From: Sarah Featherstone [REDACTED]
Sent: 22 October 2019 11:57
To: Anita Gardner <Anita.Gardner@arun.gov.uk>
Cc: Martyn White <Martyn.White@arun.gov.uk>
Subject: Re: Thatch Cottage applications CM/42/19/PL and CM/43/19/L

Thatch Cottage:

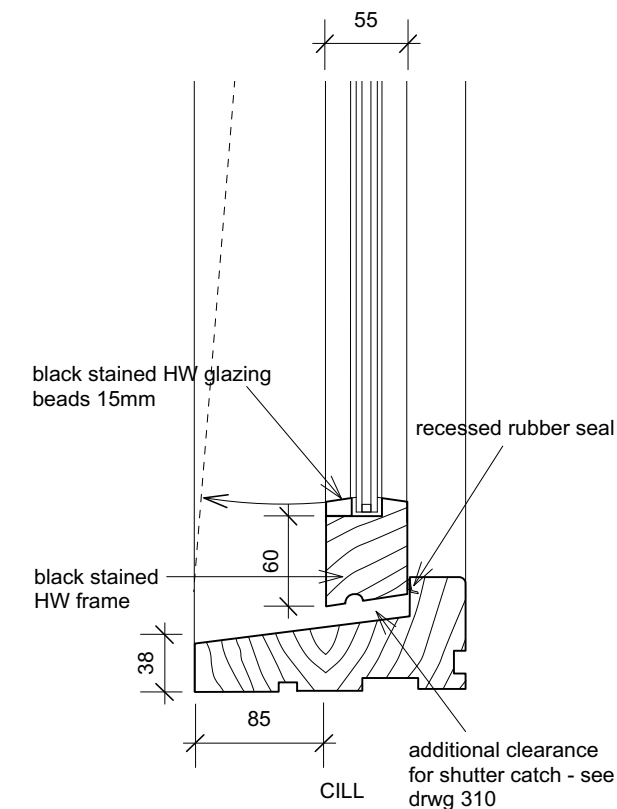
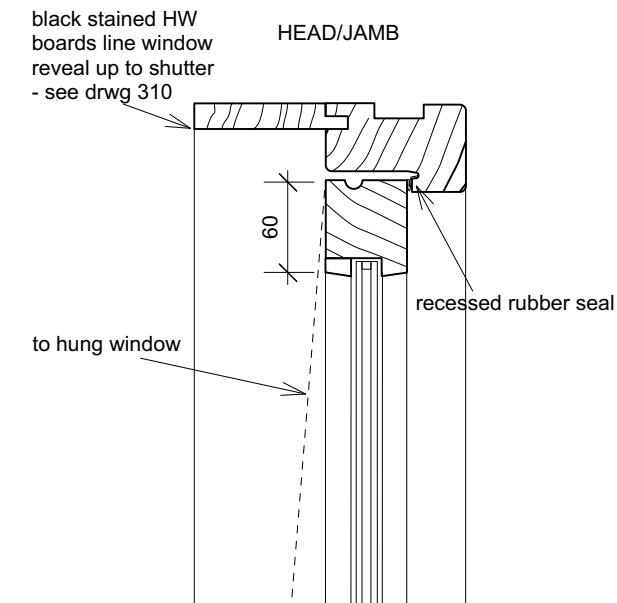
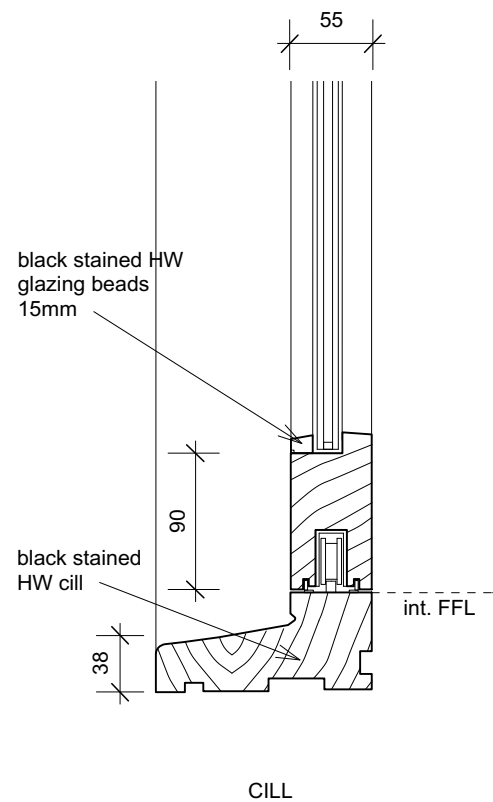
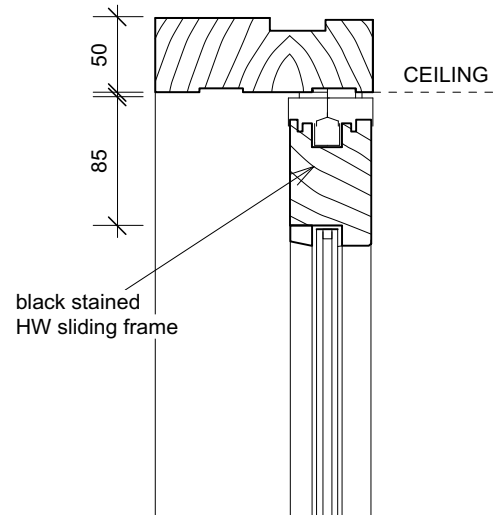
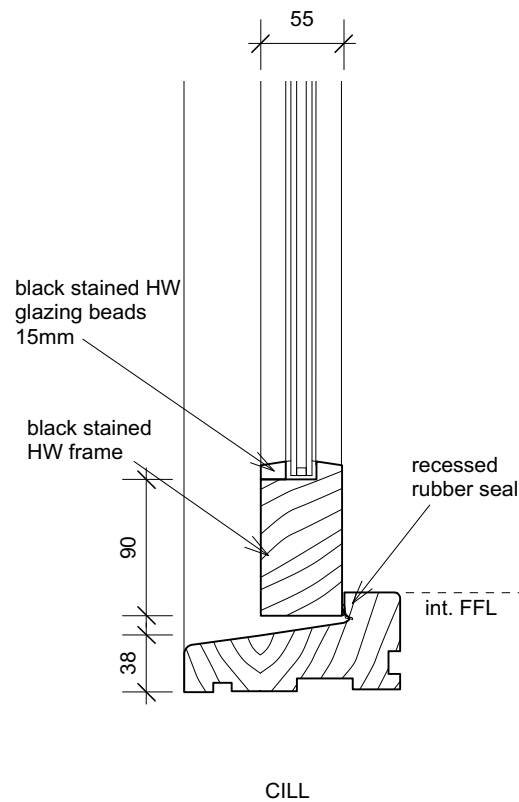
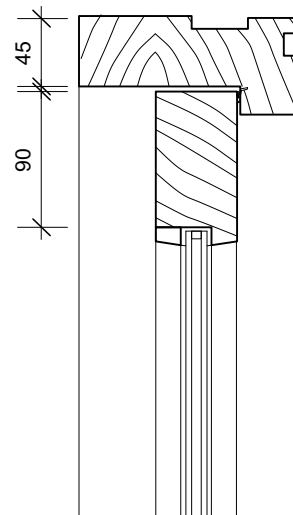
- T&G board detail used on external wall cladding of new extension
- Shutter details: Window 9 - proposed storm window - we stated "looks better if openings flush with window frame" — MW states "this is matter of detail" . We will provide a detail.

Further to our previous email responding to the conservation officers comments on Thatch Cottage - I attach a drawing 02 305 which gives a detail of T&G board detail used on external wall cladding of new extension and includes the sliding door detail for windows 3, 4 & 5 in the new extension. Drawing 00 311 provides a detail of shutters to windows in flint walls, and whilst the elevation is of a window in Mill Cottage, the details are the same for all windows in flint walls Thatch i.e.. windows 6,7,8 ,9 &10.

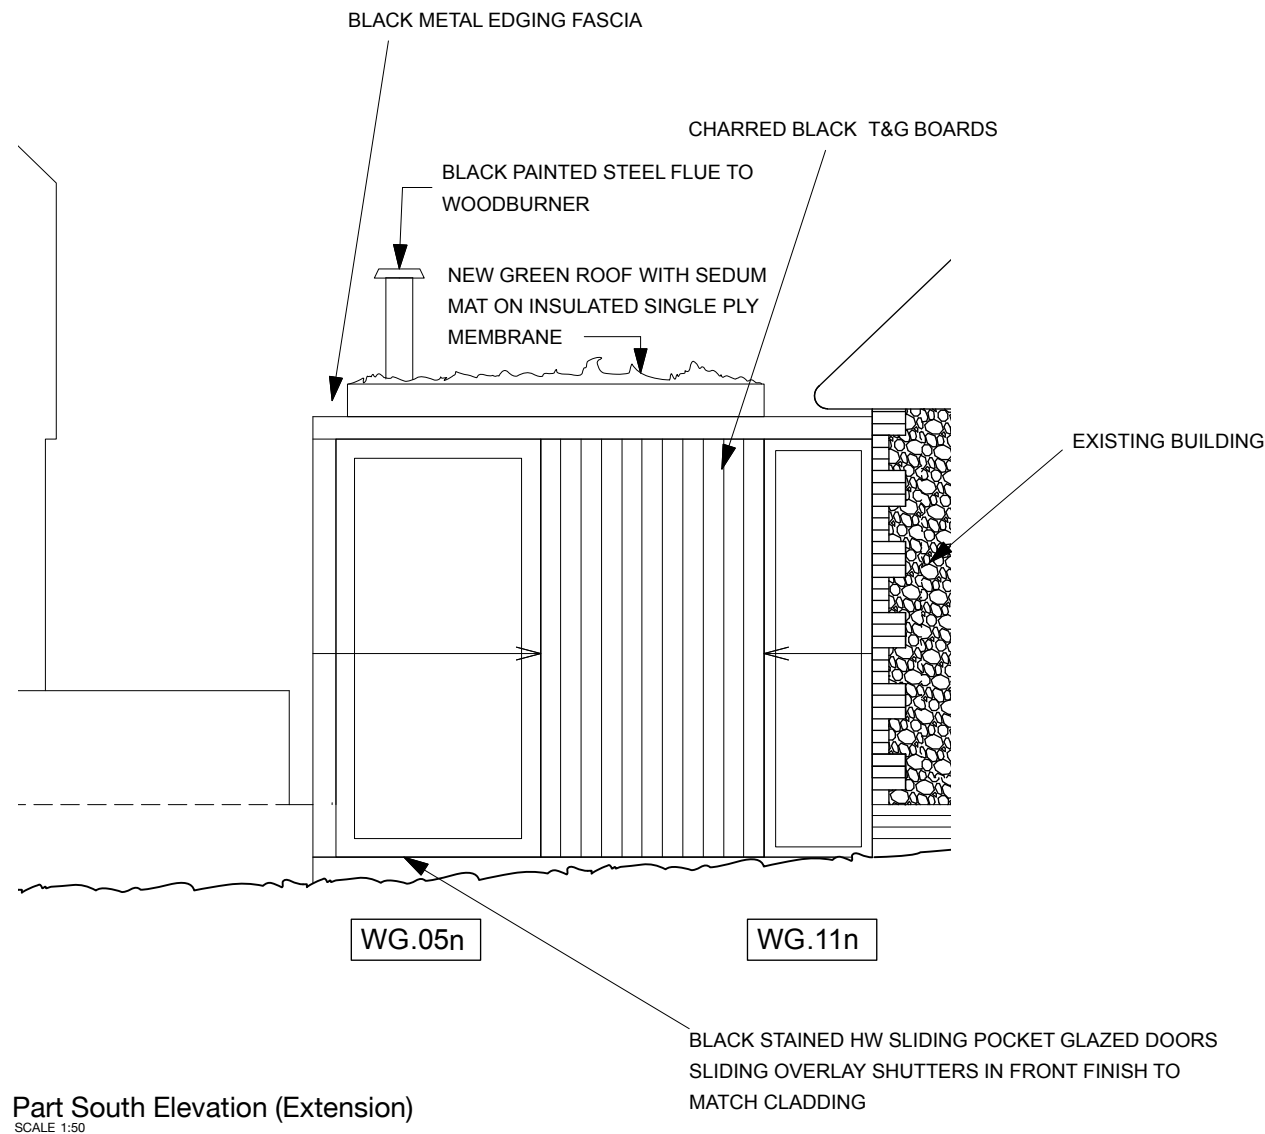
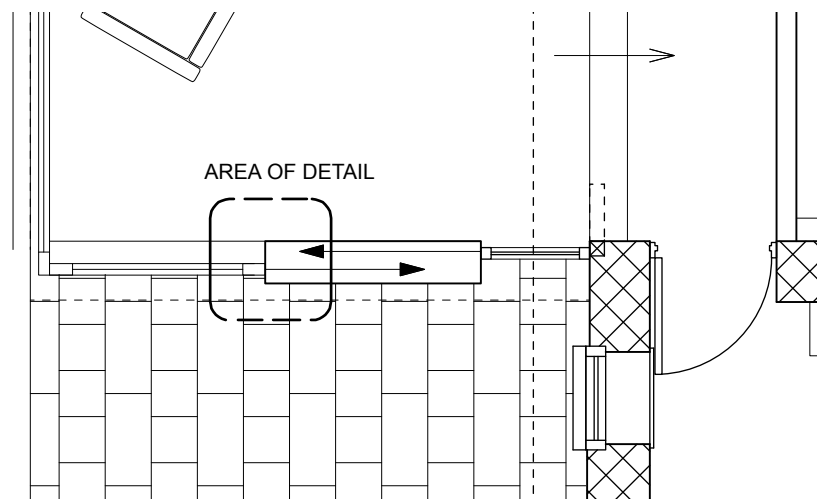
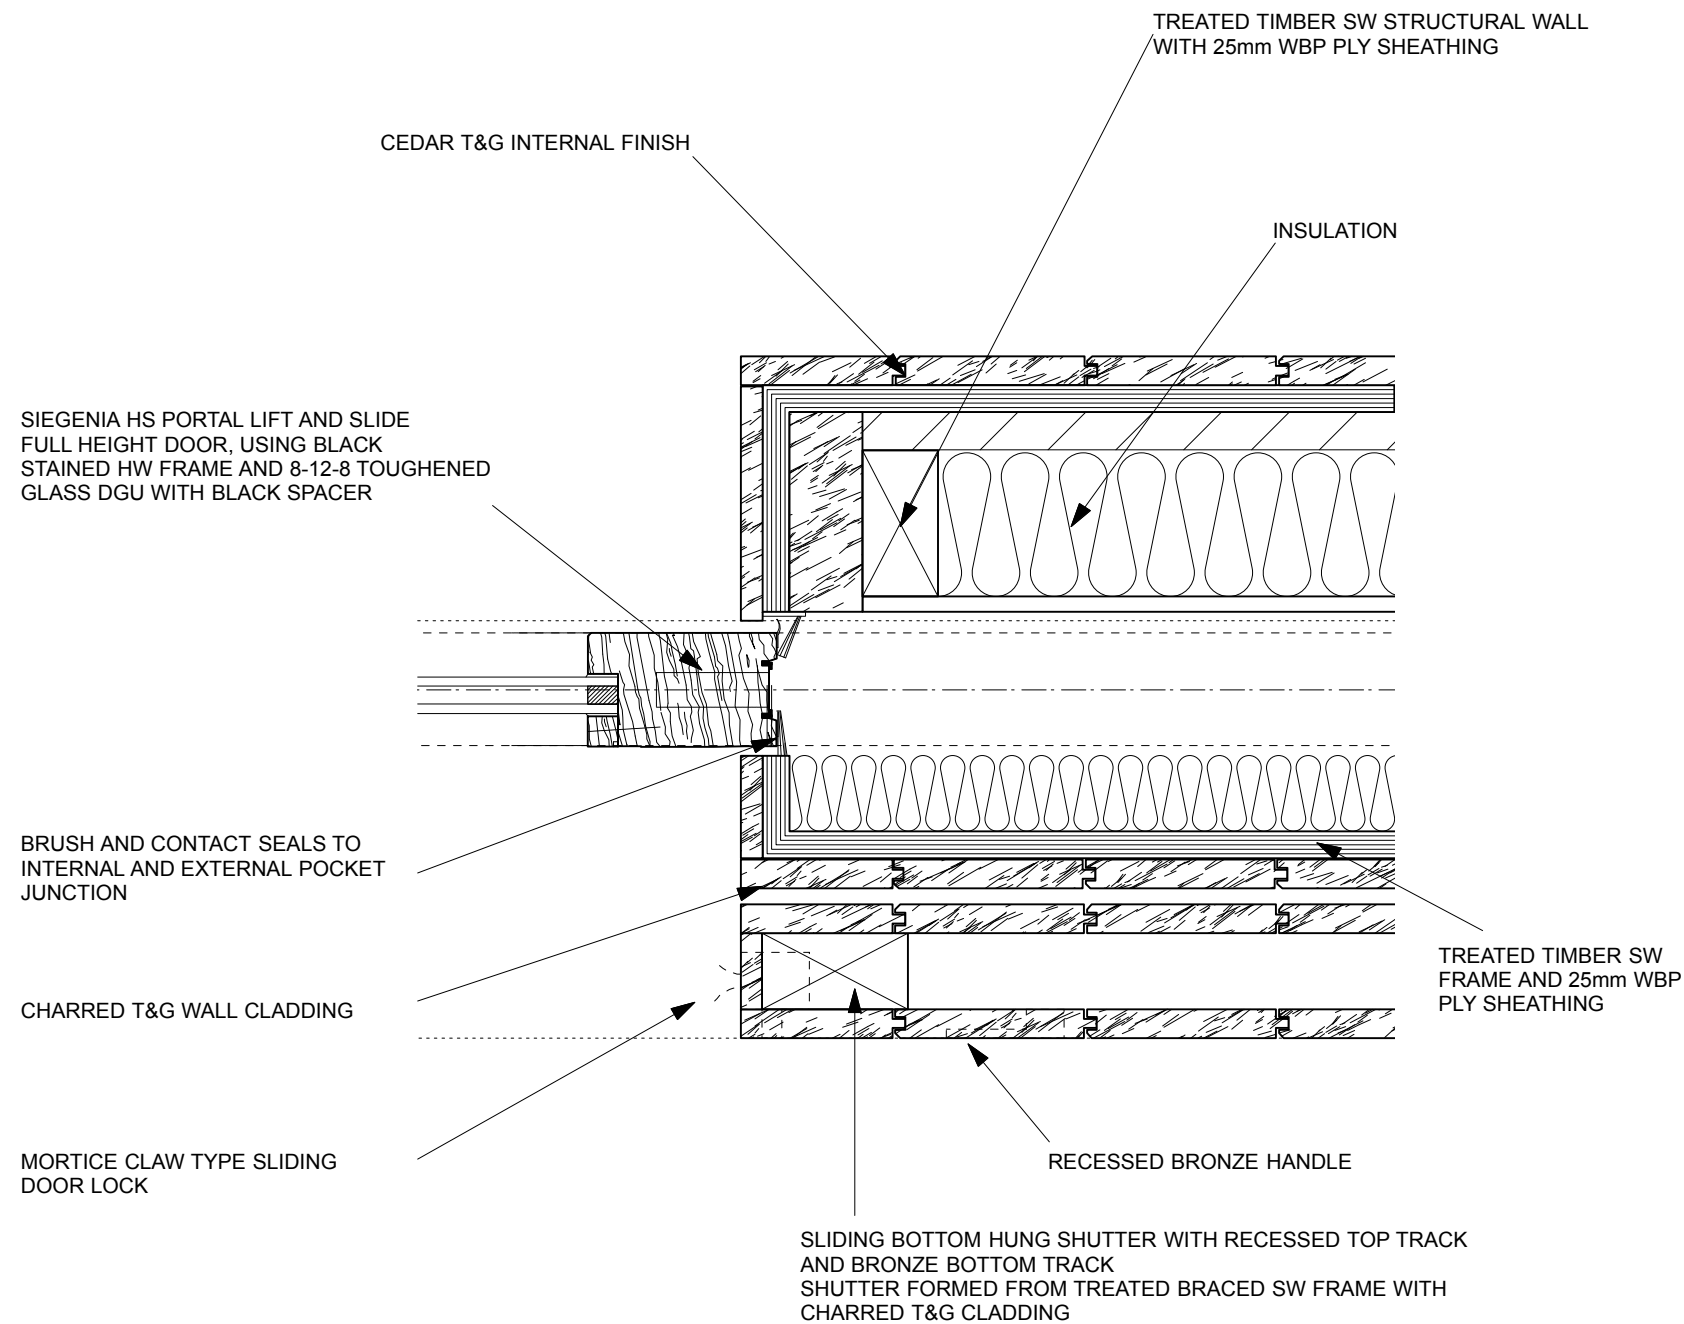
Windows 3 & 4 - we understand MW not clear how the shutters operate - they slide in front of external wall. We will provide detail.
